CITY OF ALBUQUERQUE

November 19, 2021

**RE: Sandia Peak Grid BESS Facility
Conceptual Grading and Drainage Plan
Engineer's Stamp Date: No Date
Hydrology File: D16D002A9**

Based upon the information provided in your submittal received 10/18/2021, the Conceptual Grading & Drainage Plan **is not** approved for action by the DRB on Site Plan for Building Permit. The following comments need to be addressed for approval of the above referenced project:

GRADING AND DRAINAGE PLAN	C3-2	
	DRAWING NUMBER	
SANDIA PEAK GRID BESS PROJECT	175614	A
ON NOTICE AND STATES		
SANDIA PEAK GRID, LLC	JOB NUMBER	RE\
1" = 30'

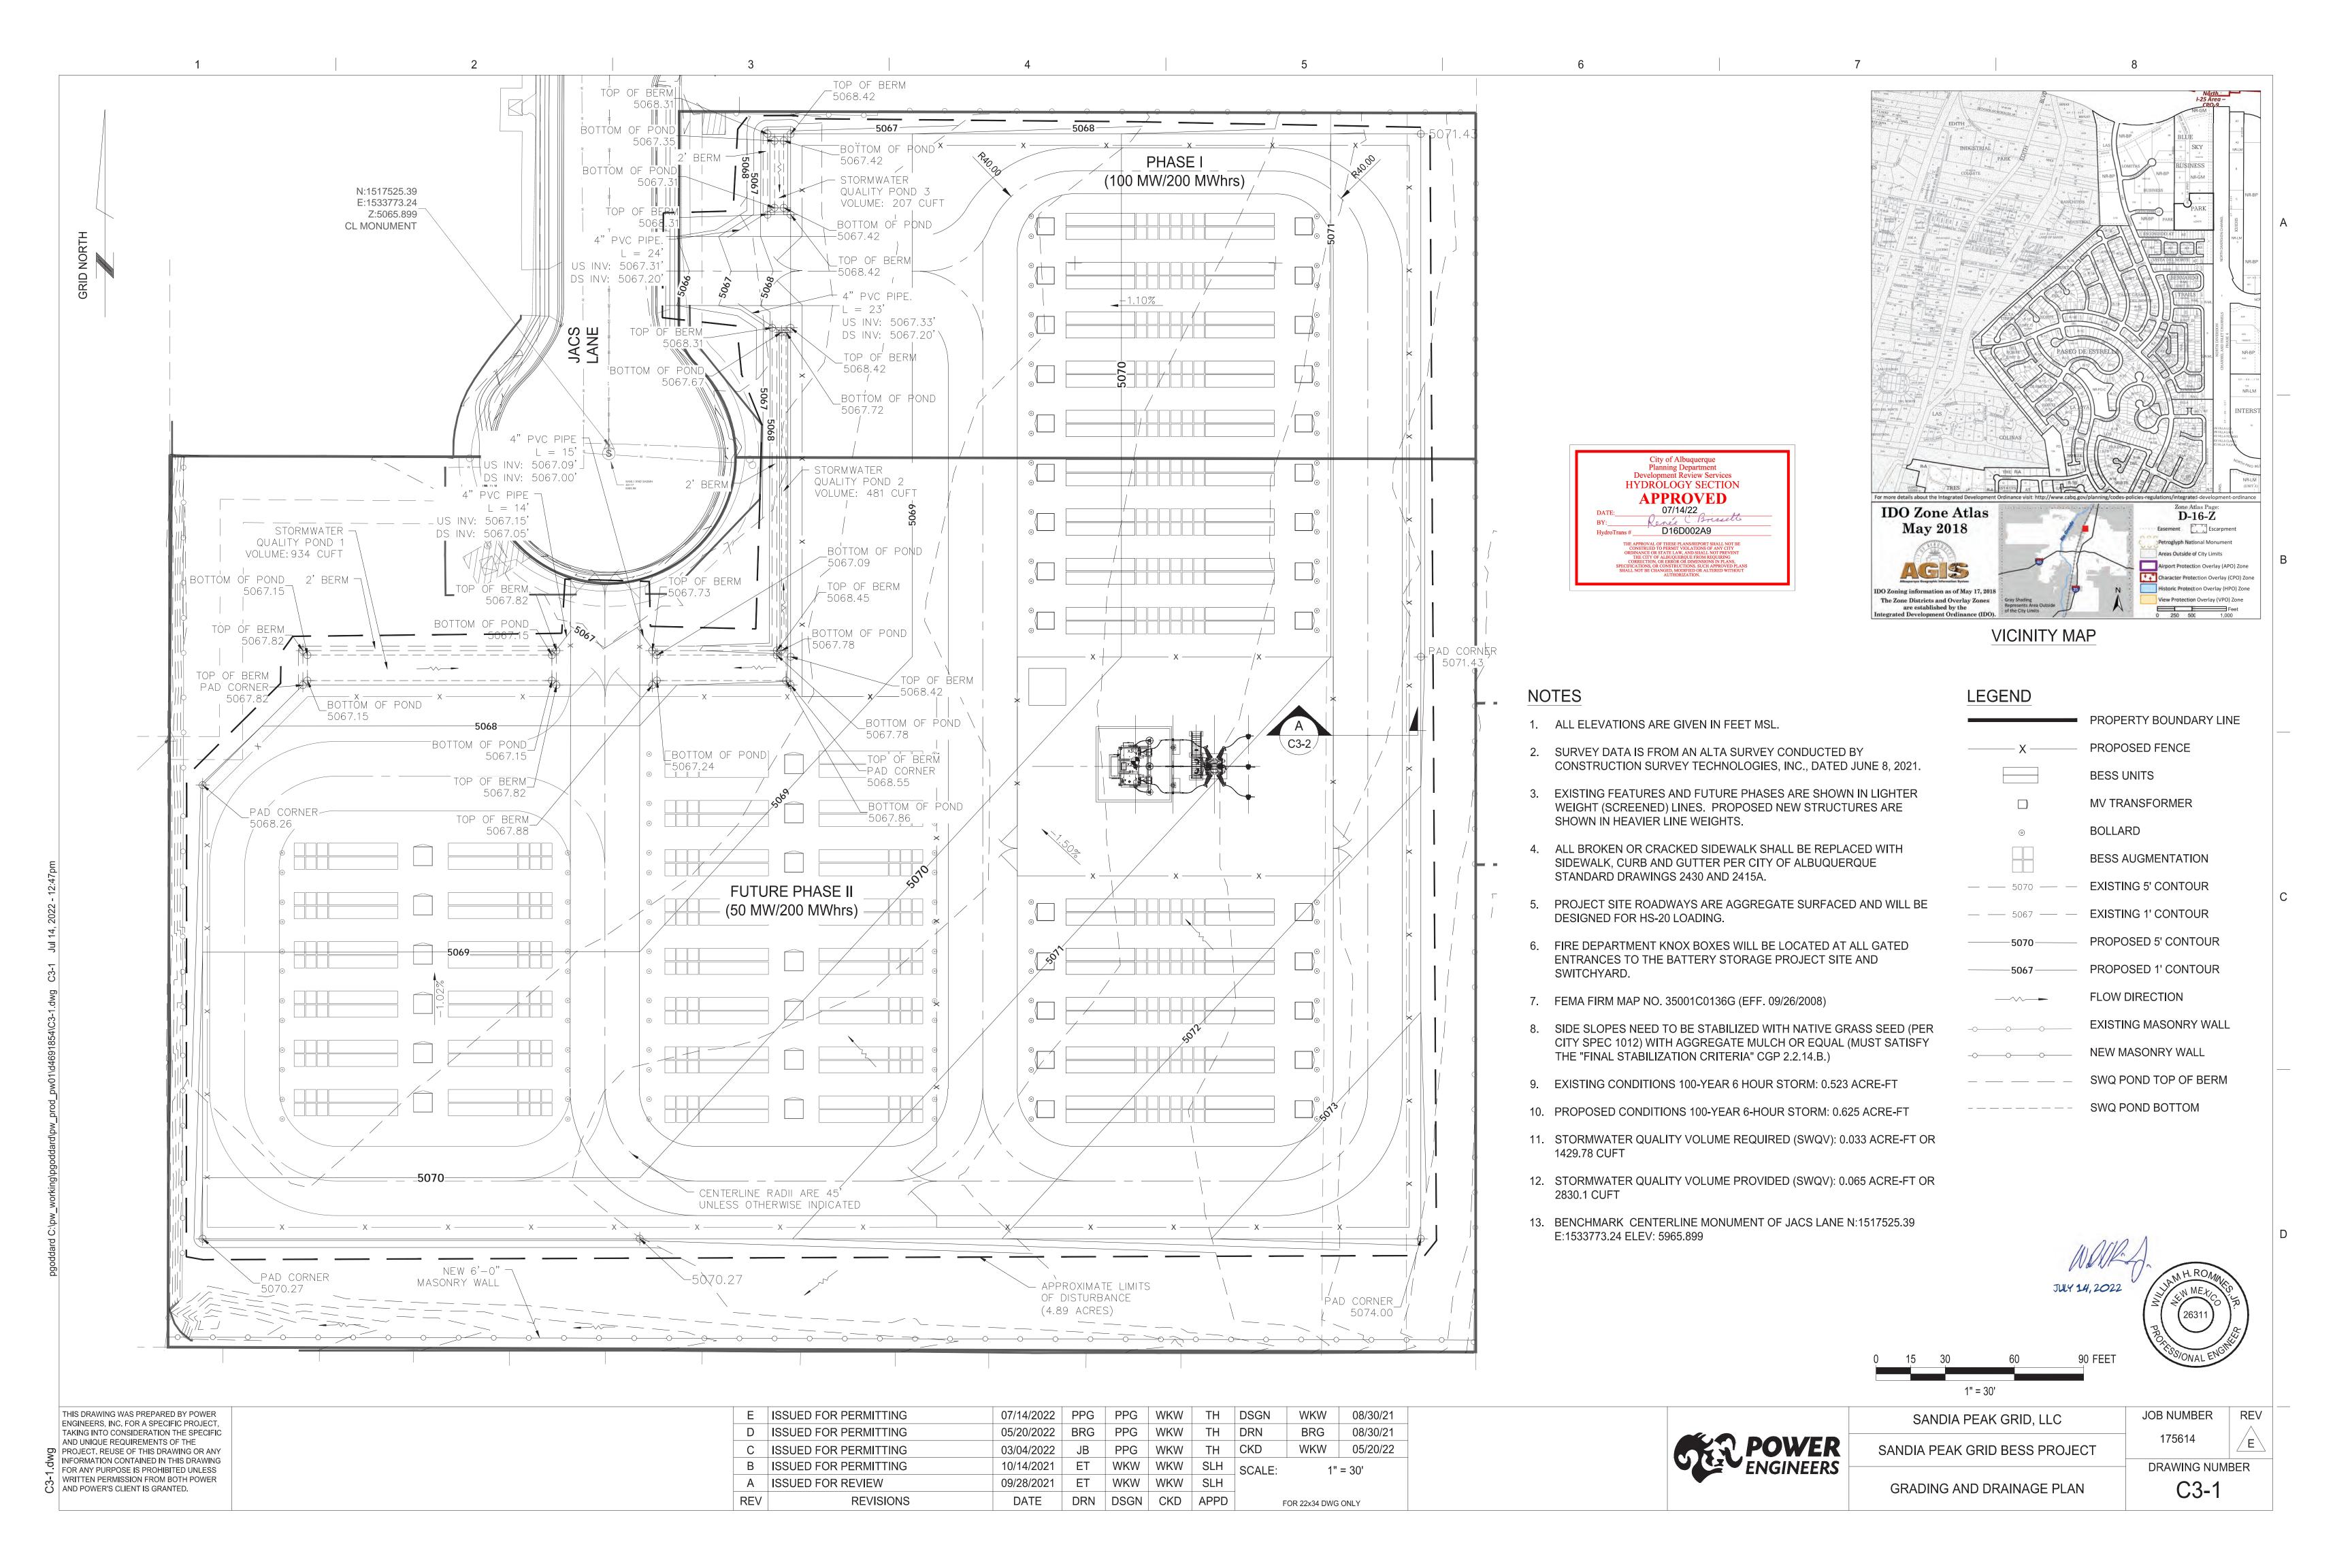
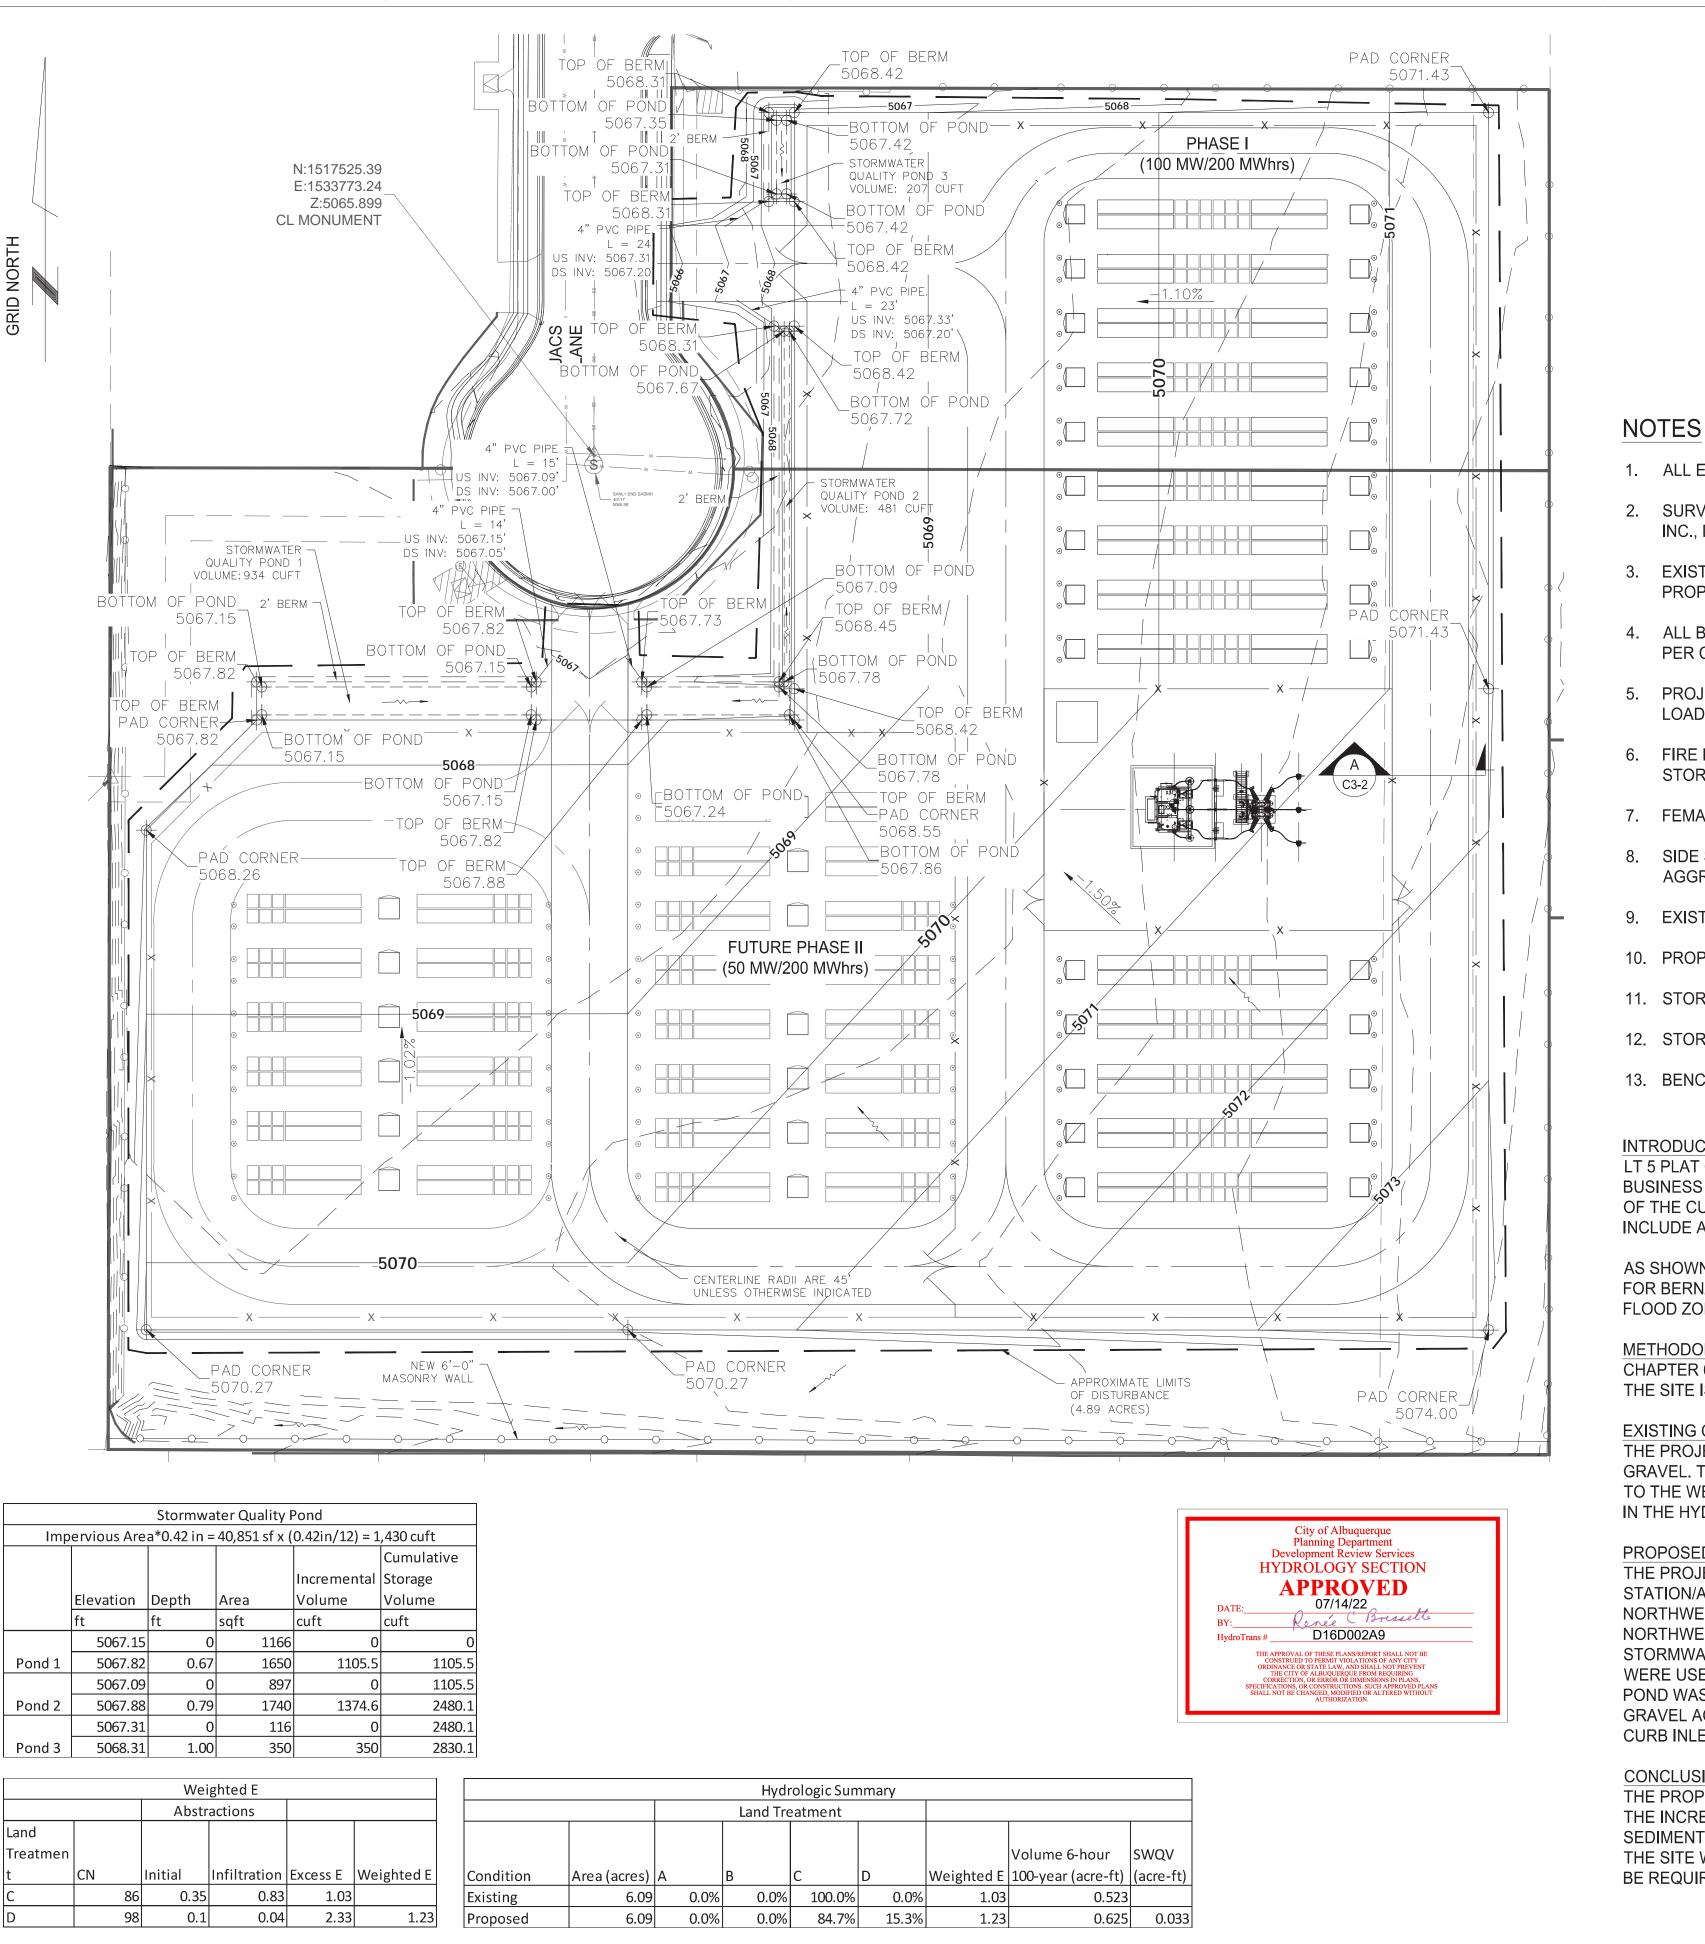
- e. Please provide the FIRM Map and flood plain note with effective date.
 - f. Please provide a legal Description of the property.
2. Provide a vicinity map showing the location of the site. Typically, this is the Zone Atlas. This can be downloaded in pdf format from the City of Albuquerque's website.

3. Please use the procedure for 40 acre and smaller basins as outlined in Development Process Manual (DPM) Article 6-2(a). Please provide both the existing conditions and proposed conditions for the 100 year-6 hour storm event.

4. Please follow the DPM Article 6-12 Stormwater Quality and Low-Impact Development for the sizing calculations. To calculate the required SWQV, multiply the impervious area draining to the BMP by 0.42 inches for new development sites.

5. Please label the SWQ pond with the provided volume.
6. Please add a note, "Side slopes need to be stabilized with Native Grass Seed (per City Spec 1012) with Aggregate Mulch or equal (Must satisfy the "Final Stabilization criteria" CGP 2.2.14.b.)". This is for the SWQ pond.
